MAJOR PROJECT ASSESSMENT
MP09_0033

***Project Application for Residential Development
3 – 5 Pymble Avenue and 5A (access handle only)
Pymble Avenue, Pymble***

Director-General's Environmental Assessment Report
Section 75I of the
Environmental Planning and Assessment Act 1979

15 July 2009

DRAWING TITLE:
E ELEVATIONS - NORTH

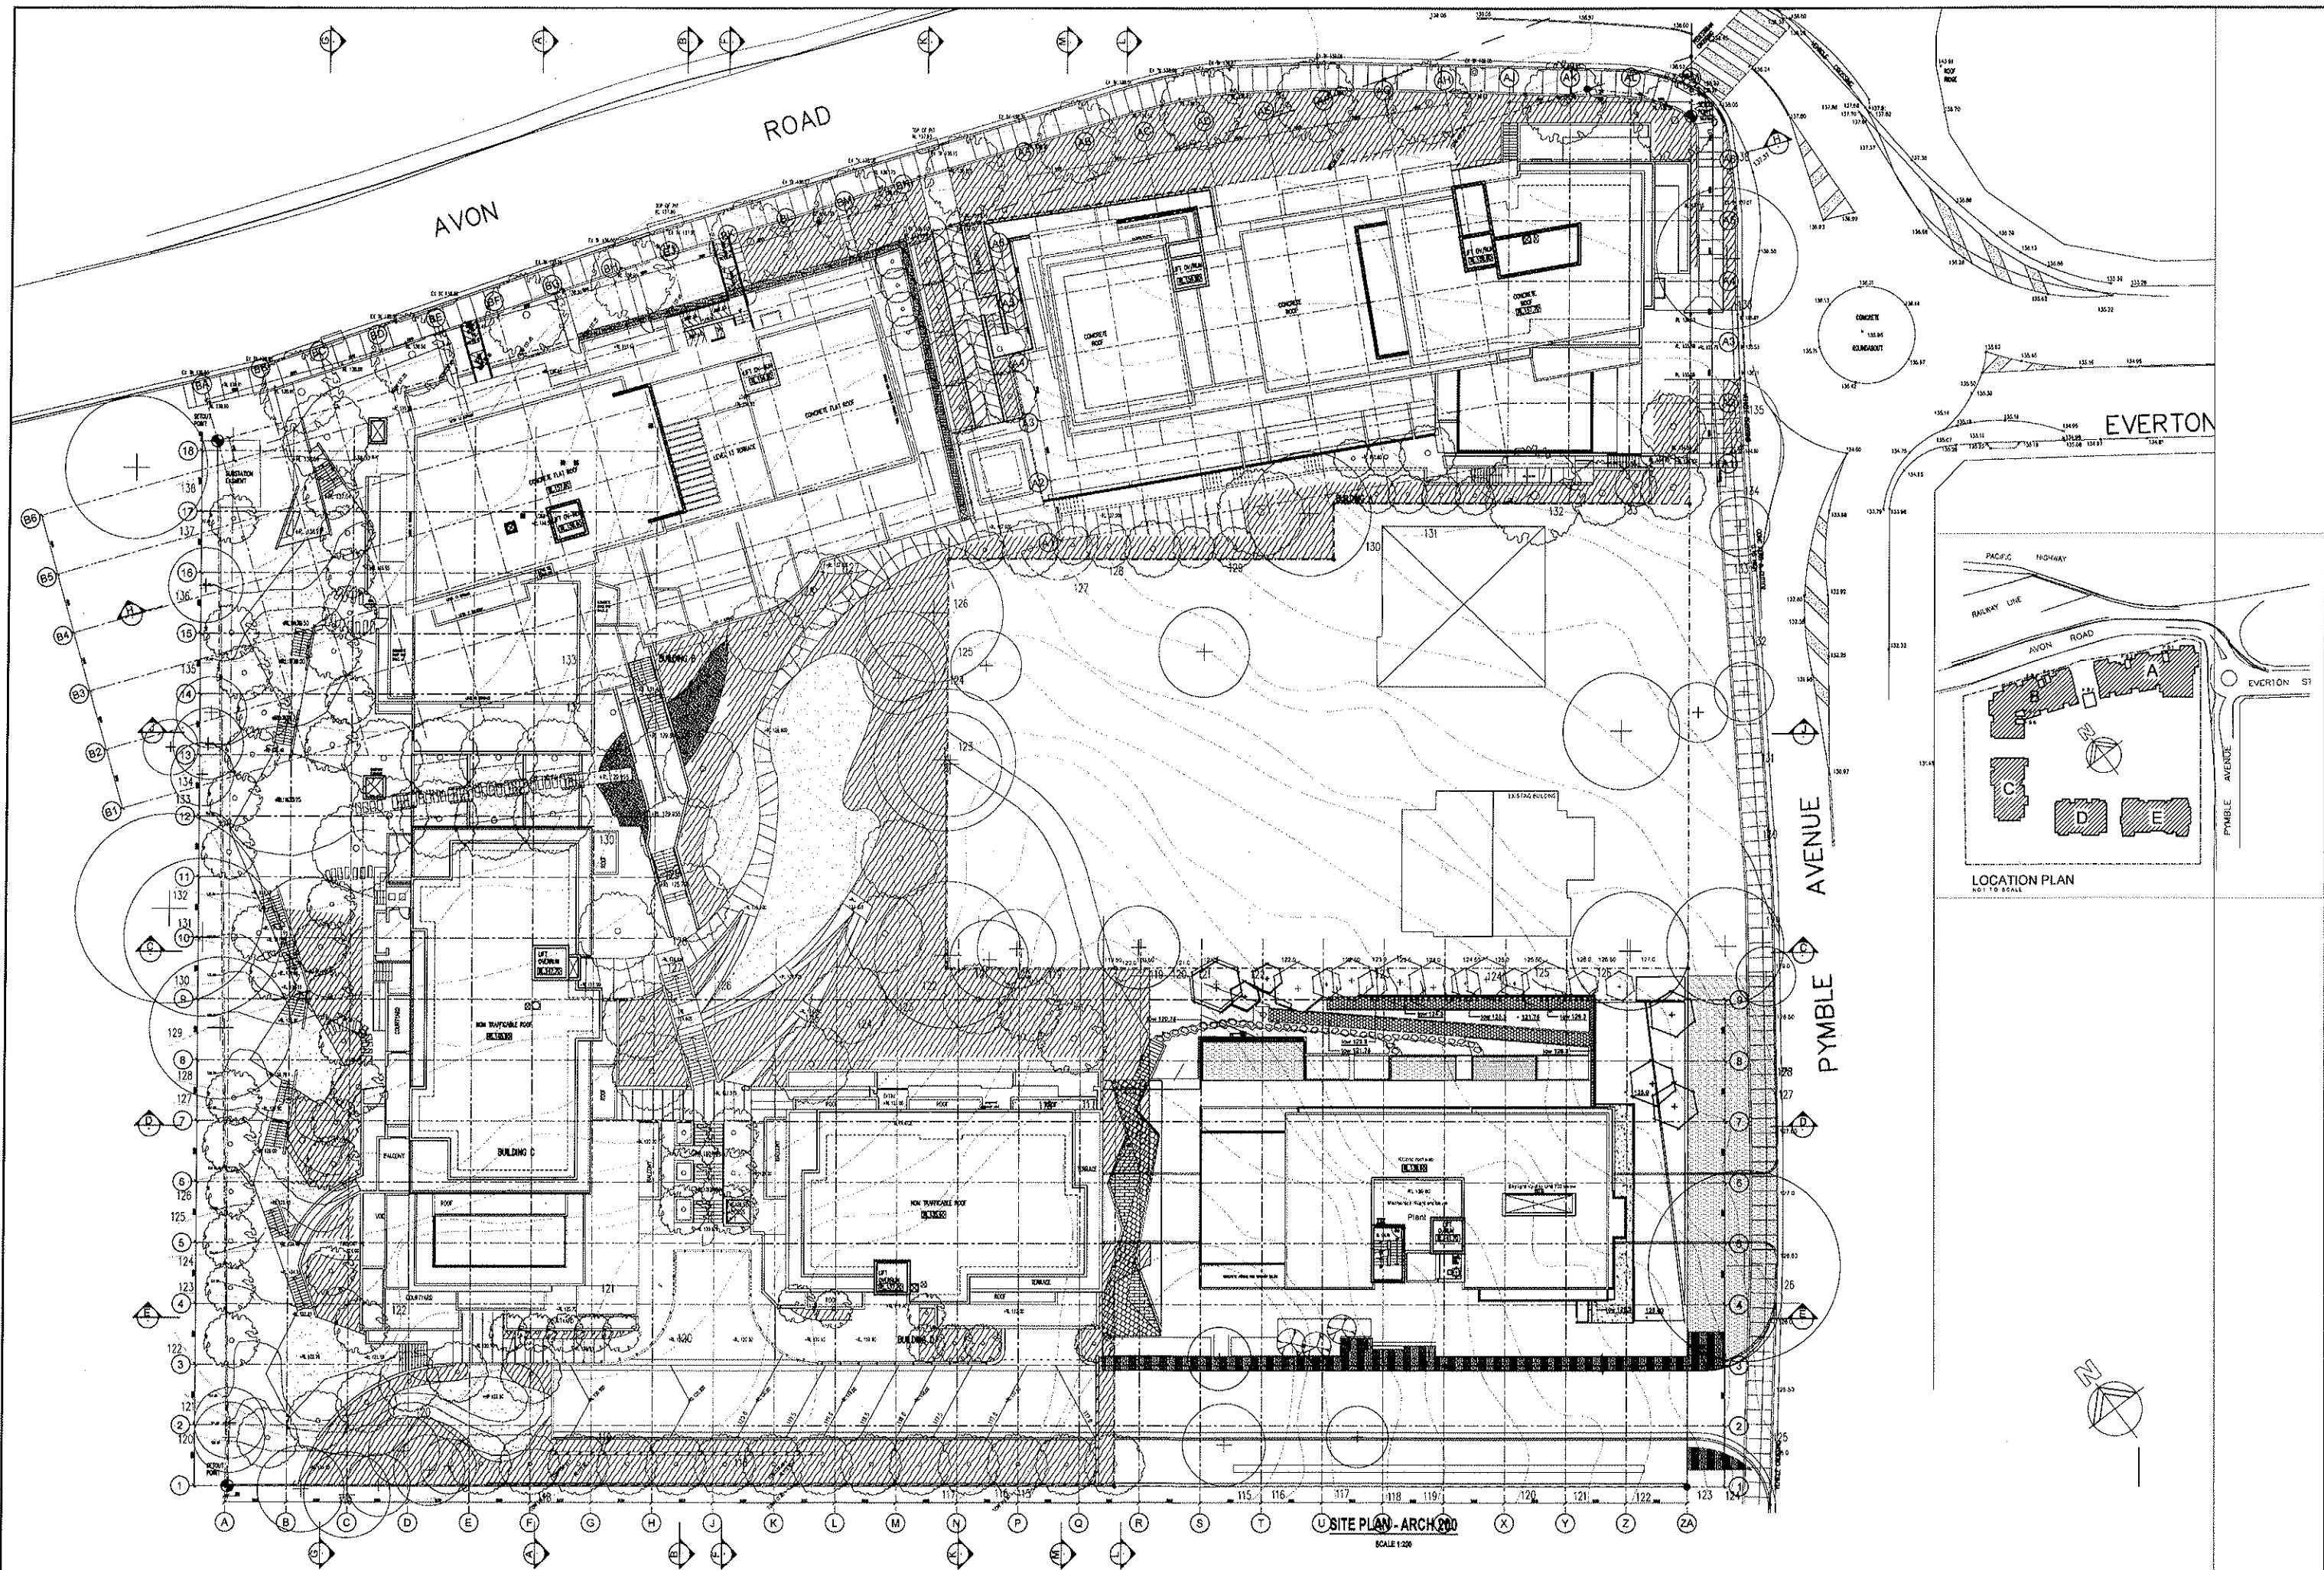
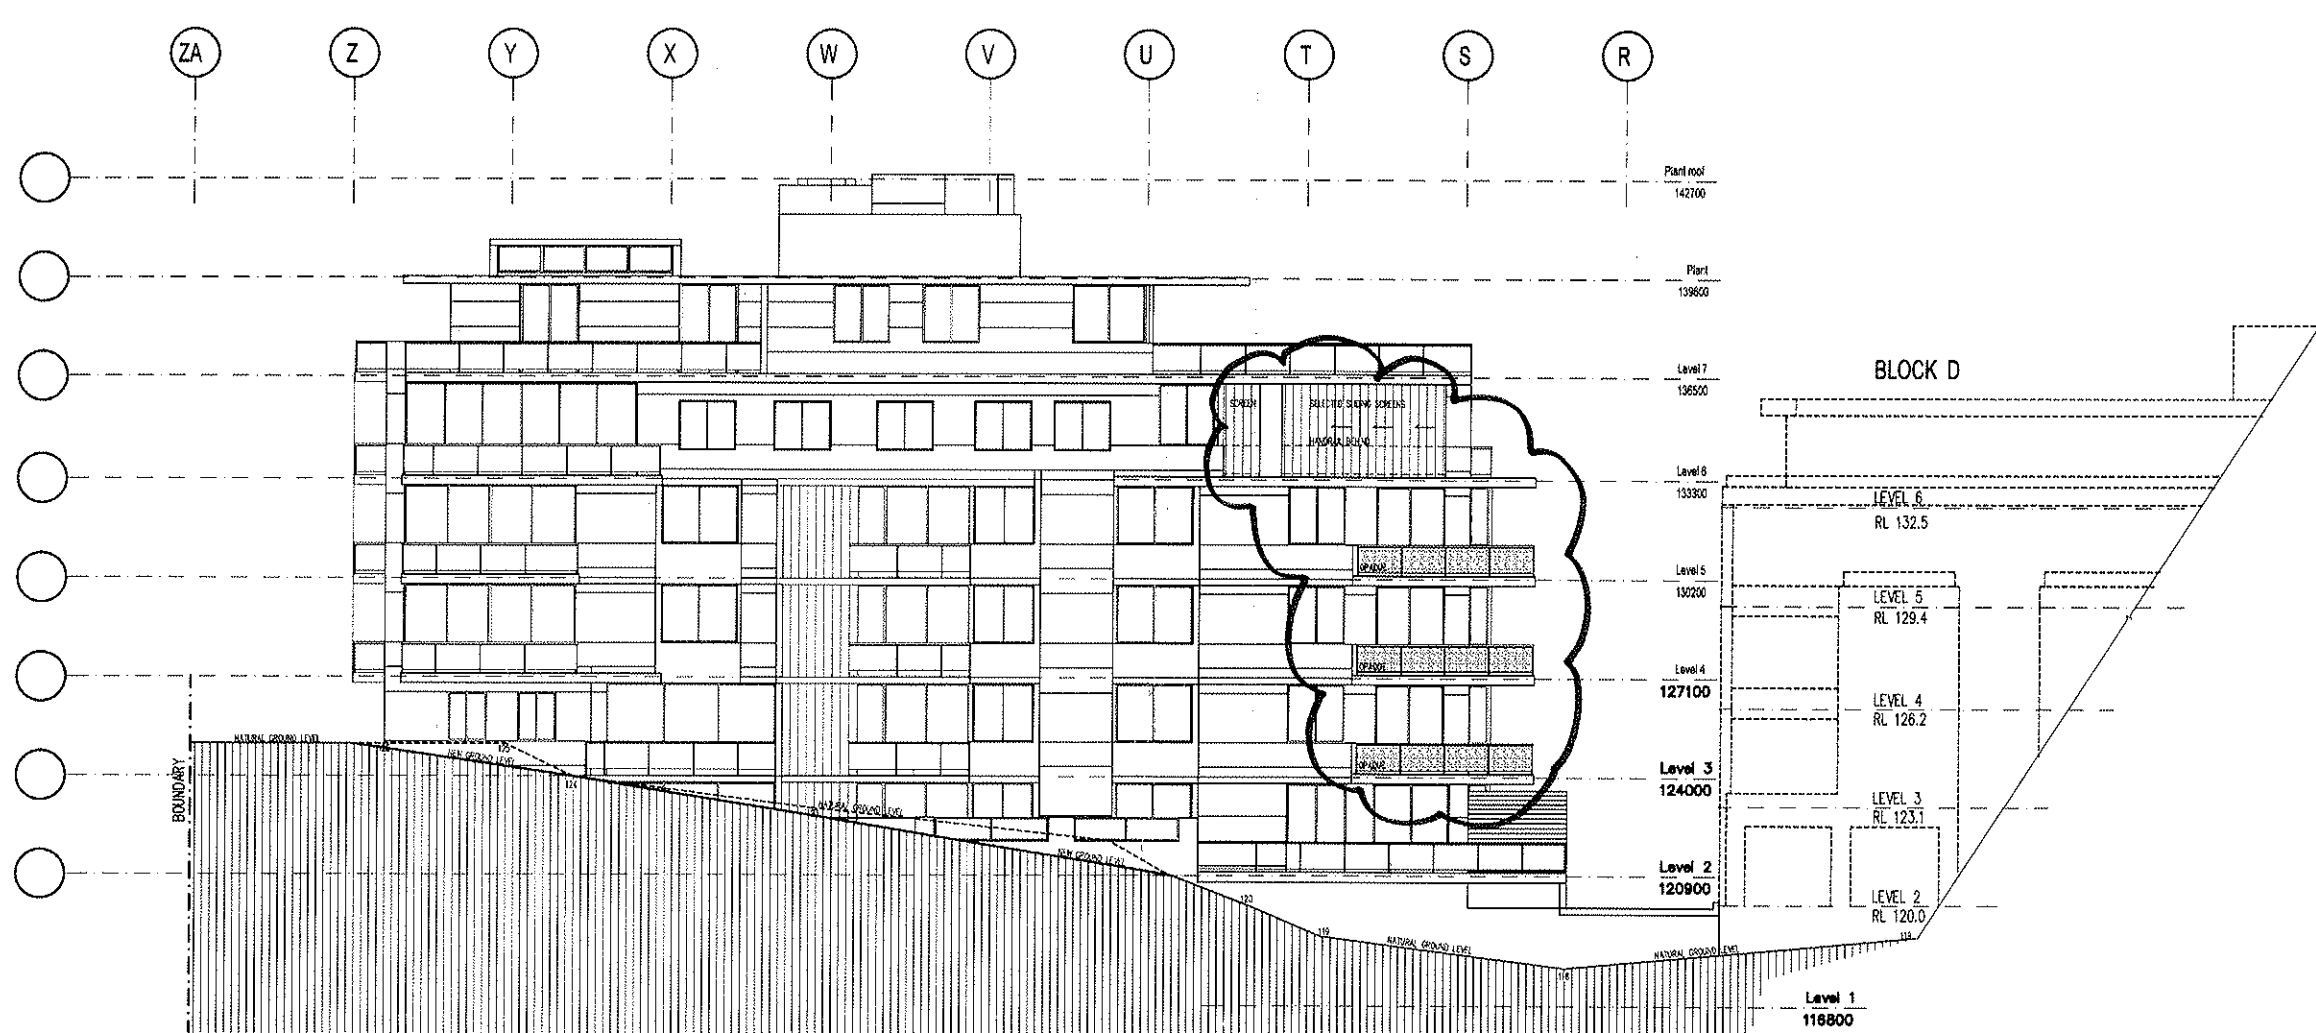
- Altered the orientation and location of the proposed balconies on the north western corner of the building so that their orientation is north-west, away from the adjoining dwellings (refer Diagram 2 above).
- Submitted a site plan showing the detailed location of the neighbouring dwellings (1 and 1A Pymble Avenue) in relation to the proposed development (building E).
- An analysis of alternative options of providing internal vehicular access into the Block F envelope (possible future development envelope for 1 and 1A Pymble Avenue) from the broader development site.

- Introduction of various design measures to improve visual and aural privacy to neighbouring properties;
- Provision of additional landscaping; and,
- Requirements for drainage easements.
